# **Consultee Comments for Planning Application**

Application Number: 1/0998/2021/FUL

Proposal: Erection of single storey dwelling

On Behalf Of: Environmental Protection Officer

Foul Waste Connection Statement

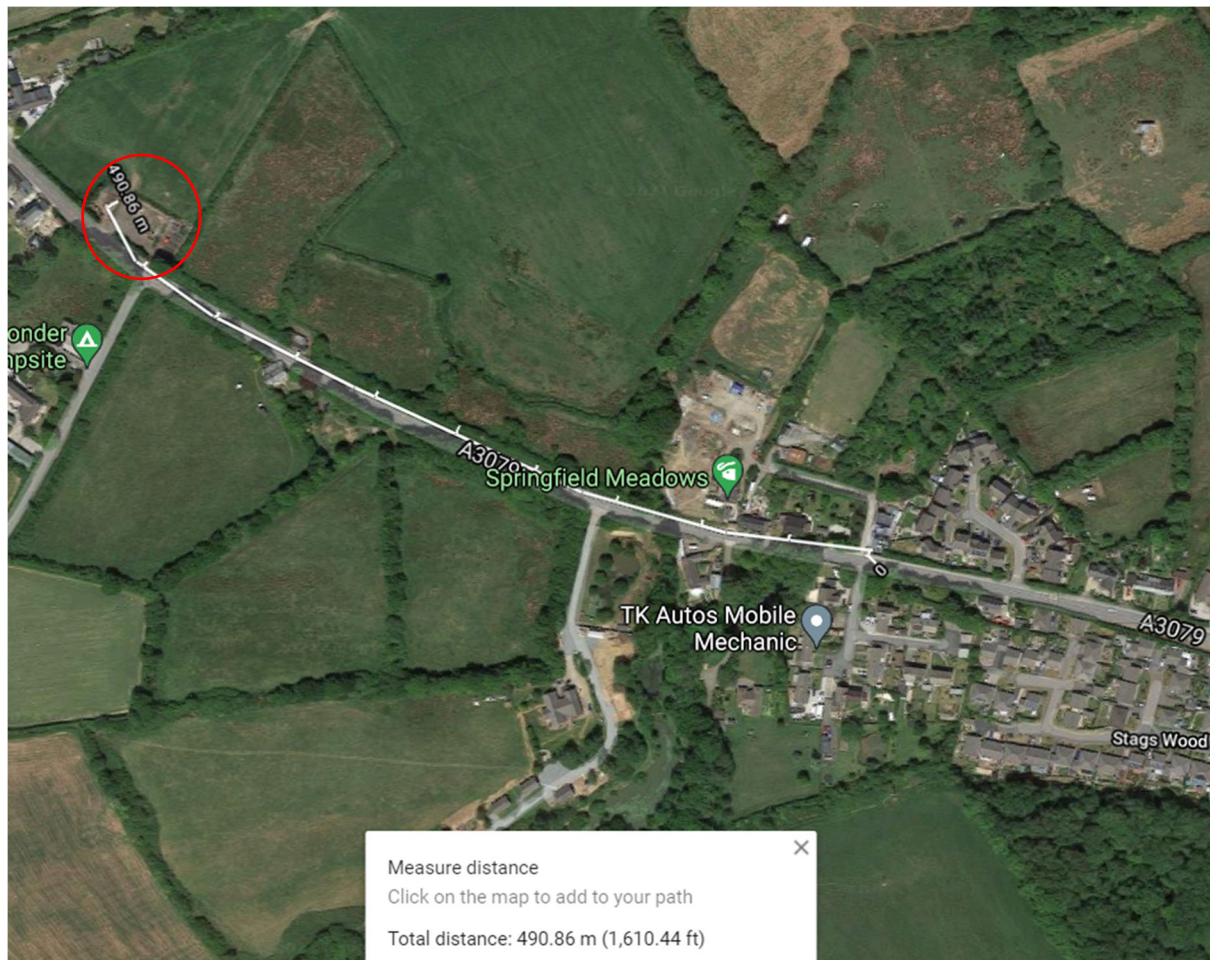
It is noted that the proposed dwelling will be served by a new non-mains foul drainage provision. The percolation test results do not appear to be available making it difficult to comment on the suitability of the ground for the proposed drainage field. The Environmental Protection Team will

require the percolation test results and calculated drainage field area to be provided for review in order to ensure the proposed dwelling is served by a suitable and satisfactory foul drainage provision.
